Please scan as a rep under CM/16/20/PL

Plot 8 deliberate misrepresentation by applicant MJH Homes to ADC

Drawing Title:
HOUSE TYPE-F1
FLOOR PLANS

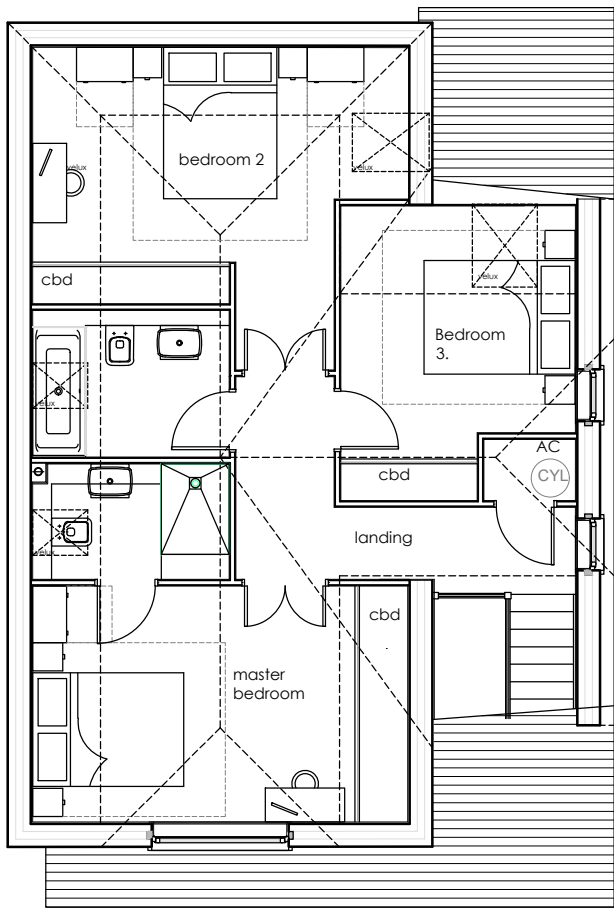
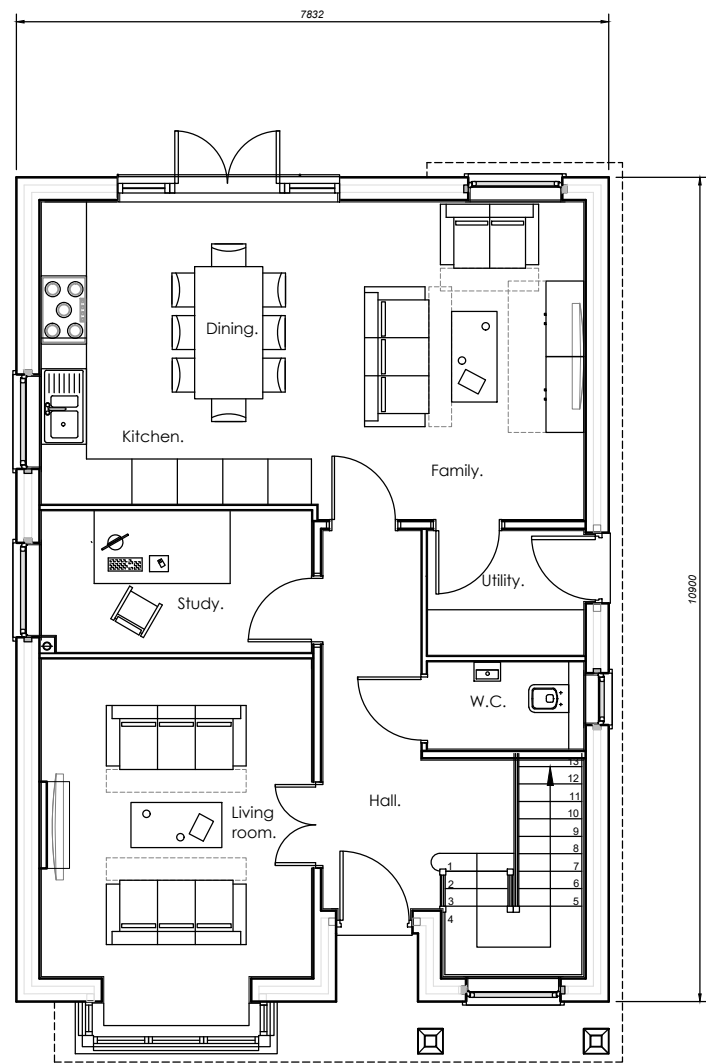
4. PLOT 8 runs the length of my boundary. An application for a 4-bed house type E has been superseded by House type F described as a **3-bed BUNGALOW**. Having looked at the plans this is a **HOUSE** with 2 bedrooms and 2 bathrooms on the first floor, and one bedroom on ground floor. The whole length of the proposed house runs the whole length of my boundary, with permanent structure within feet of my fence. This is very intrusive, and will obliterate light for the majority of the day, completely unacceptable. I speak on behalf of myself and my affected neighbours.

Project:
LANGFORD
HORSEMERE GREEN LANE
CLIMPING
Drawing Title:
HOUSE TYPE-F1
ELEVATIONS

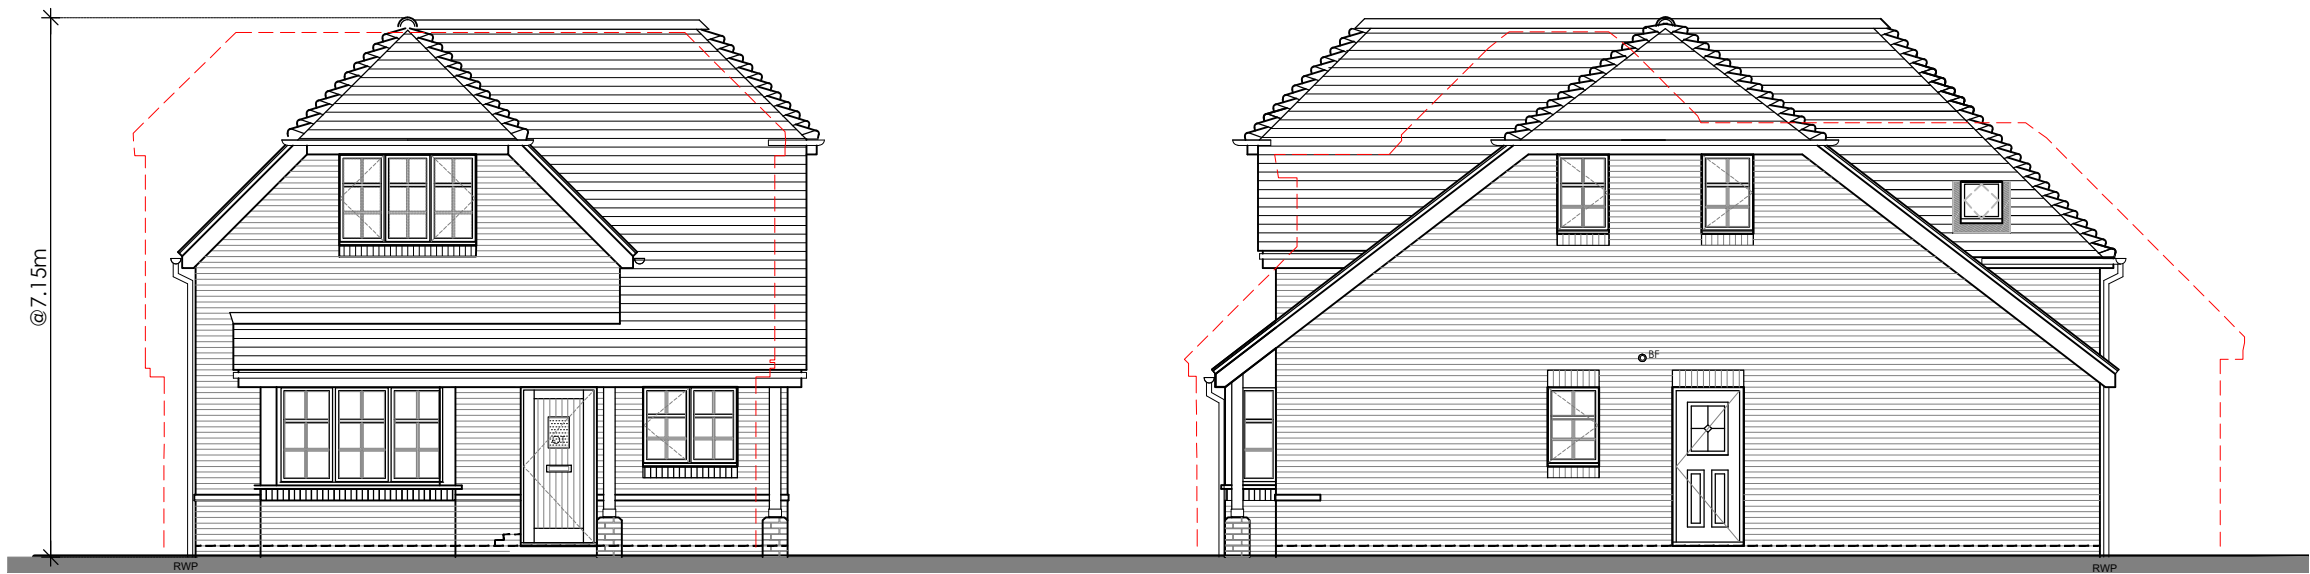
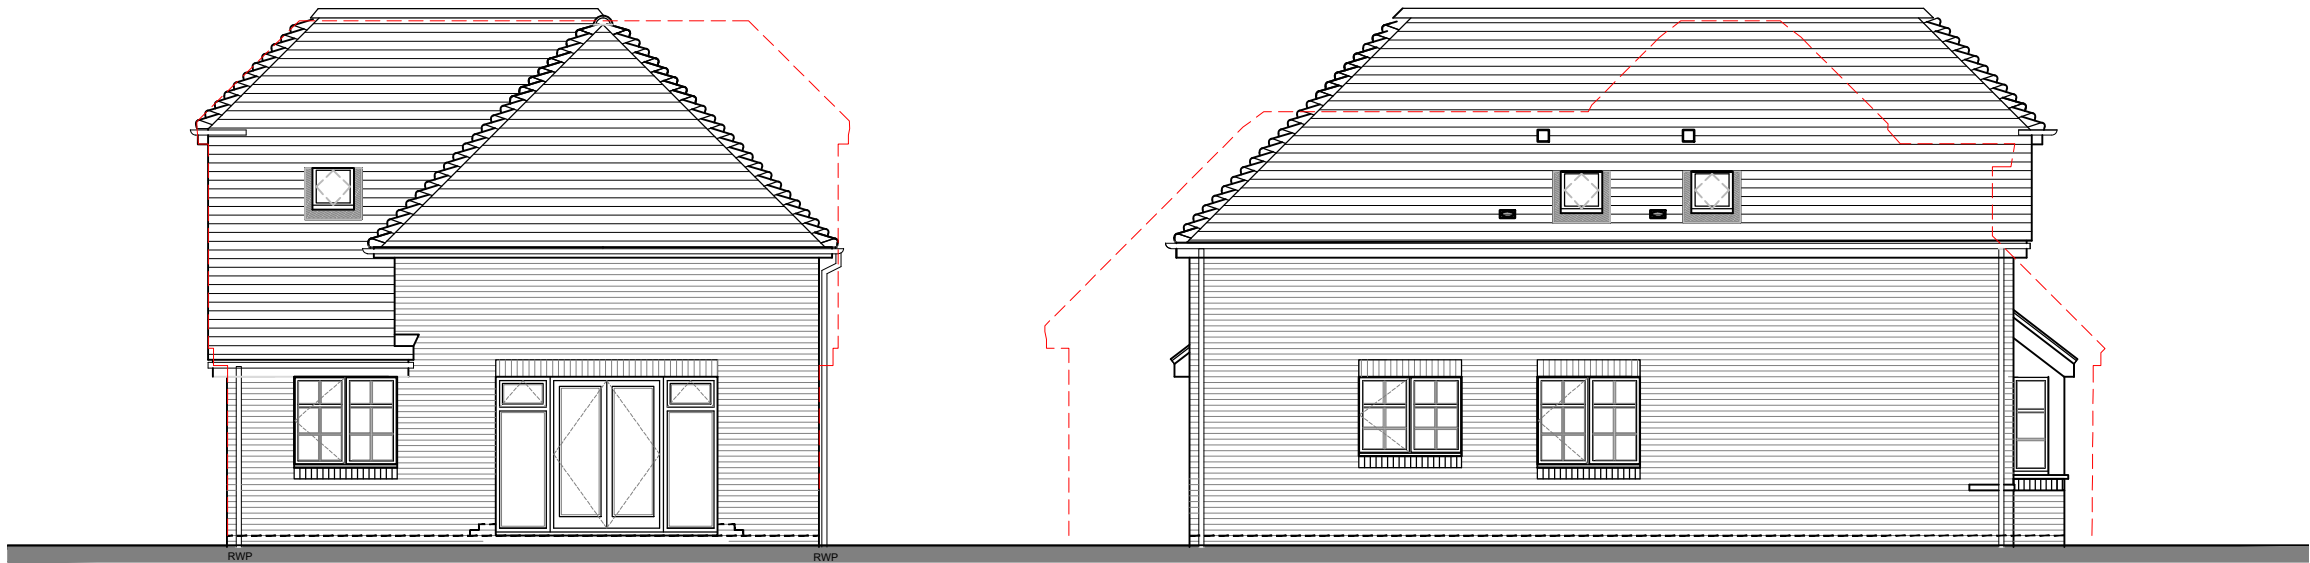
7. If the applicant were to reduce the roof height to single storey, ie, that of a bungalow, as proposed, and lower the ground level, this would fall in line with their proposal of '**2 x 3-bed bungalows**' made to Arun District Council.
